Council Reference: DA09/0701.03 LN35979
Your Reference:

**TSC Submission Altitude Aspire Residential Subdivision
MP09/0166 MOD 3 (Council Reference DA09/0701.03)**

I refer to your e-mail of 11 April 2018 in which you notify Tweed Shire Council of the subject Modification. The application has been reviewed by Council Officers and the following comments are for your consideration during the assessment of the application.

NEWLAND DEVELOPERS PTY LTD	
TERRANORA PRECINCT 1 CENTRAL OPEN DRAIN SWALE PLAN	
09-374 21.09-2017	SK3618 REVISION E

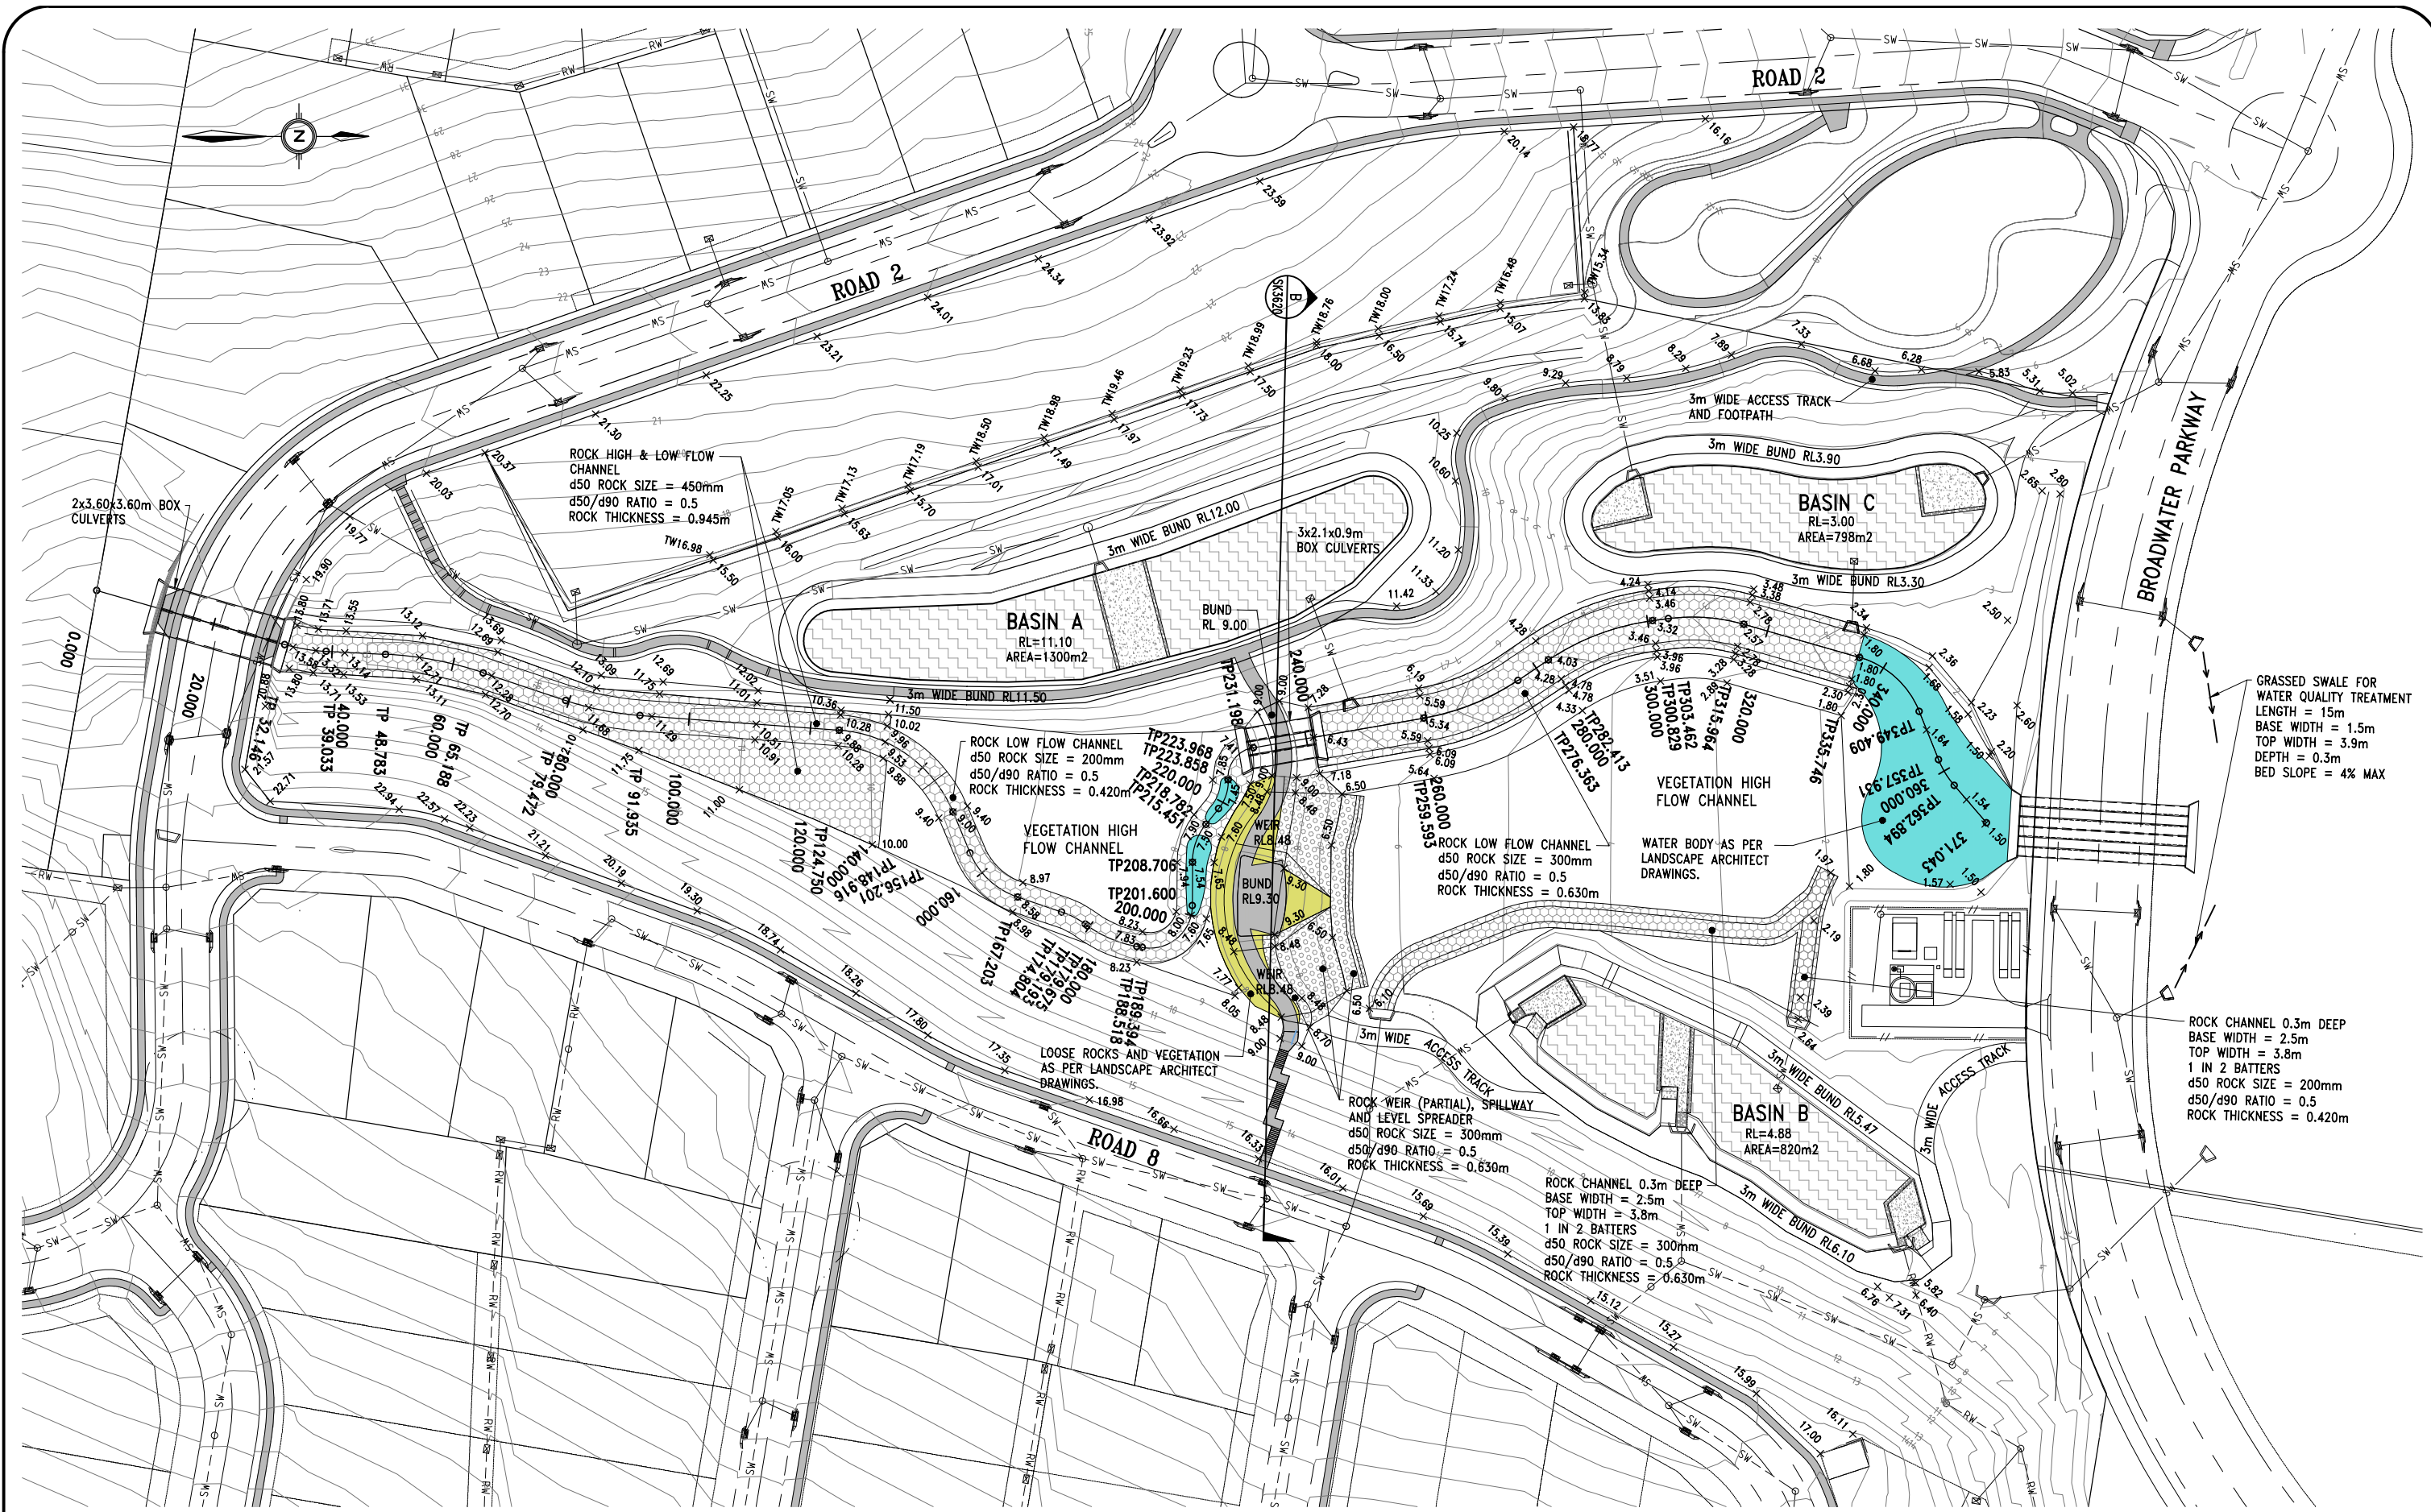
- f. The 'water bodies' shown on Bradlees plan SK3618 Rev.E and SK 3626 Rev.D, being adjacent to the SPS as well as small ponds mid-site, are not supported and are to be deleted.
- g. The proposed 'swales' on the northern side of Broadwater Parkway are not supported. These are intended to be biofiltration swales to treat the runoff from Broadwater Parkway, in lieu of an originally approved 4th biofiltration basin within the main central drainage corridor.
